# Southampton to London Pipeline Project

Response to the Examining Authority's First Written  
Questions Landscape and Visual (LV) (1 of 2)

Application Document: 8.6.08

November 2019

Figure 10.3: Landscape Constraints and Representative Viewpoints (14 Sheets)

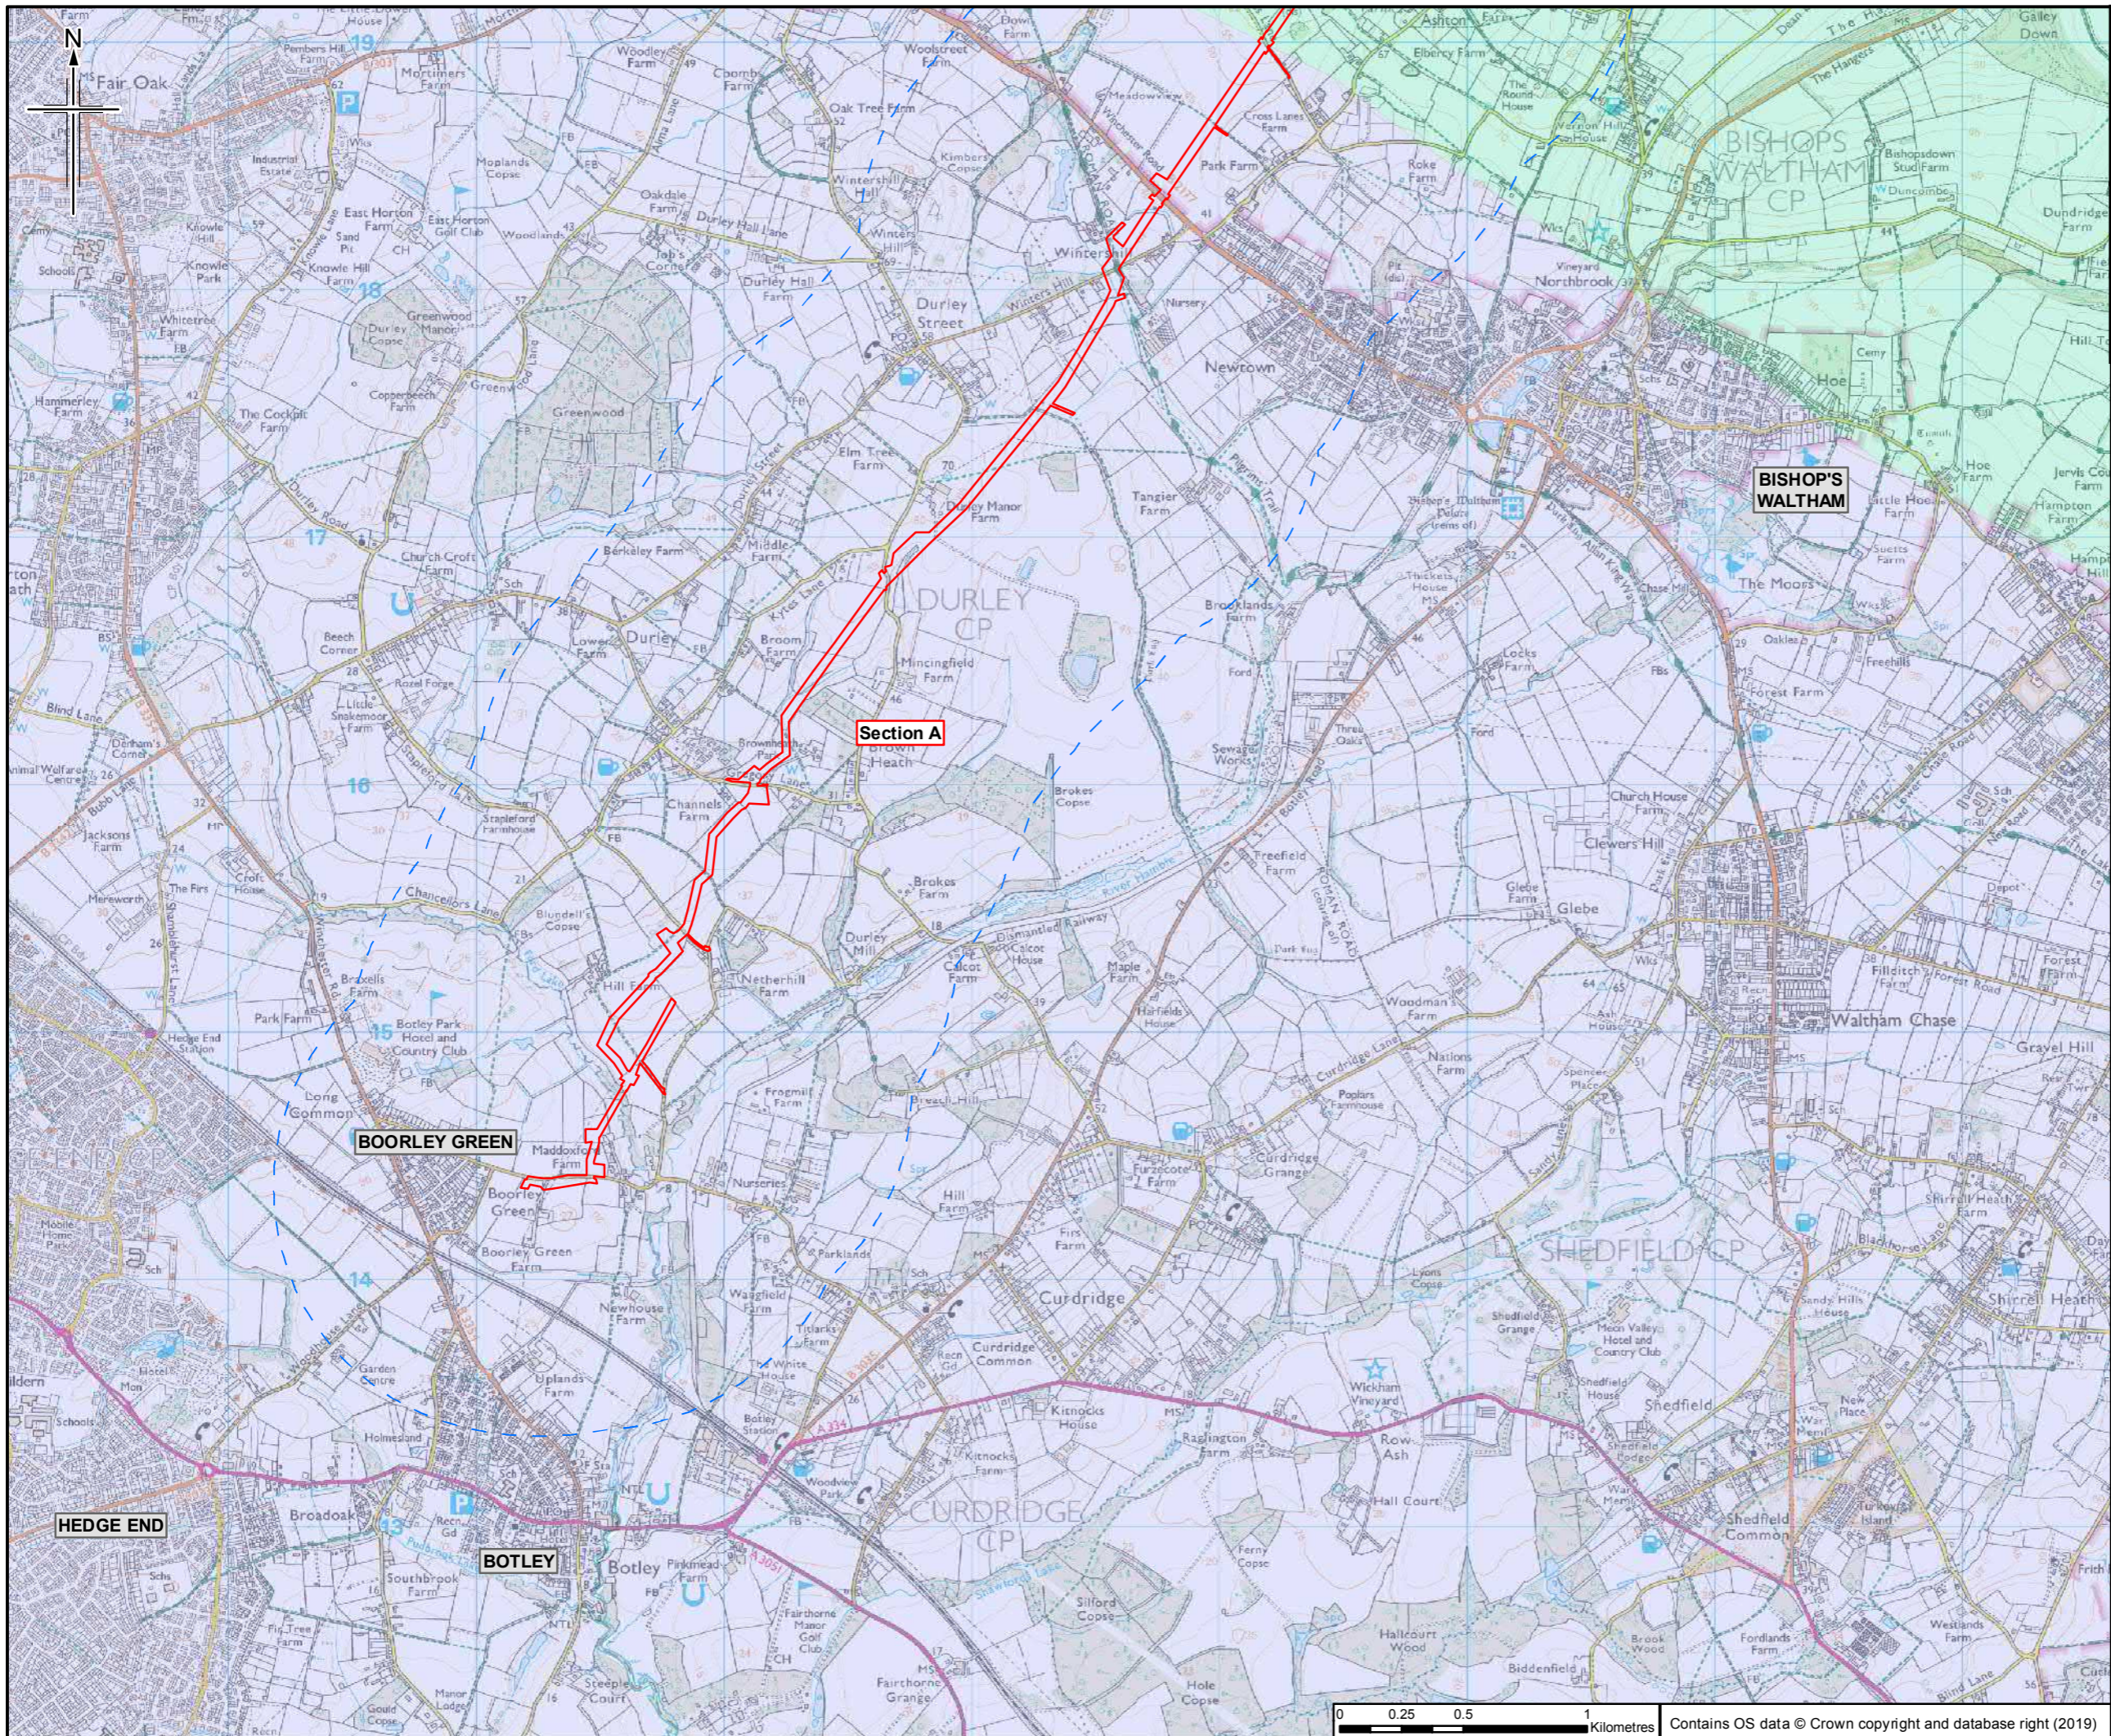
<b>LV.1.5</b>	Figure 10.4 of the ES [APP-064] show the existing views of the route. With few exceptions, the vegetation is in leaf. Paragraph 10.2.26 describes a winter survey being undertaken in early 2018, and states "The findings of the winter landscape survey were used to help influence the developing design and inform the	<p>1.1 In response to i), paragraph 10.2.26 of Environmental Statement Chapter 10 (<b>Application Document <a href="#">APP-050</a></b>) further explains that '<i>An initial winter landscape survey was undertaken by landscape architects in early 2018 to gain familiarity with the landscape character, to gain an understanding of the general extent of visibility towards the project area from the surrounding landscape and to identify potential significant views towards the project area when visibility was most open prior to vegetation coming into leaf...</i>'.</p> <p>1.2 Photographs taken during this initial winter landscape survey provided an informal record of the site visits undertaken in early 2018 and were only one of many factors used to help influence the developing design and inform the final selection of Representative</p>

ExQ1	Question:	Applicant response to Question:
	<p>choice of Representative Viewpoints.”</p> <p>i) Explain why these winter photographs, which were used to help influence the design and confirm representative viewpoints, were not submitted into the Examination; or</p> <p>ii) Provide these photographs.</p>	<p>Viewpoints. It was not therefore considered necessary to submit these ‘working’ photographs with the Development Consent Order application.</p> <p>1.3 As requested in ii), the Applicant has provided these photographs in Appendix LV.1.5.1 of this document.</p>
<b>LV.1.6</b>	<p>Chapter 6 of the ES [APP-046] states the matrix approach used for determining the impact significance. However, there are no definitions of the significance criteria negligible, minor, moderate or major which are set out in Illustration 6.1, which is recommended by</p> <p>Guidelines for Landscape and Visual Impact Assessment 3 (GLVIA3). Paragraph 6.4.10 states “A significant effect in relation to the EIA Regulations is taken to mean a moderate or higher adverse or beneficial significance. Effects of minor or negligible significance are not</p>	<p>1.1 The Infrastructure Planning (Environmental Impact Assessment) Regulations 2017 (the ‘EIA Regulations’) require determination of whether an effect is significant or not. The EIA Regulations do not require determination of levels of significance.</p> <p>1.2 Guidelines for Landscape and Visual Impact Assessment, Third Edition (GLVIA3) (Landscape Institute and Institute of Environmental Management and Assessment, 2013) does not state that it is necessary to define significance criteria. The focus is instead on whether the effect is significant or not.</p> <p>1.3 In accordance with GLVIA3 paragraph 5.55 option 1, the level of significance of landscape and visual effects within Environmental Statement (ES) Chapter 10 (<b>Application Document APP-050</b>) has been determined in terms of the relationship between the sensitivity of receptors and the magnitude of landscape and visual change, guided by the matrix shown in Illustration 6.1 of ES Chapter 6 (<b>Application Document APP-046</b>). Paragraph 5.54 of GLVIA3 states ‘<i>There may also be a need to adopt a consistent approach across all EIA topic areas and the EIA co-ordinator will need to be involved in the decisions on suitable approaches</i>’. The approach across all EIA topics was to base the assessment of significance on the matrix shown in illustration 6.1 of ES Chapter 6 (<b>Application Document APP-046</b>).</p>
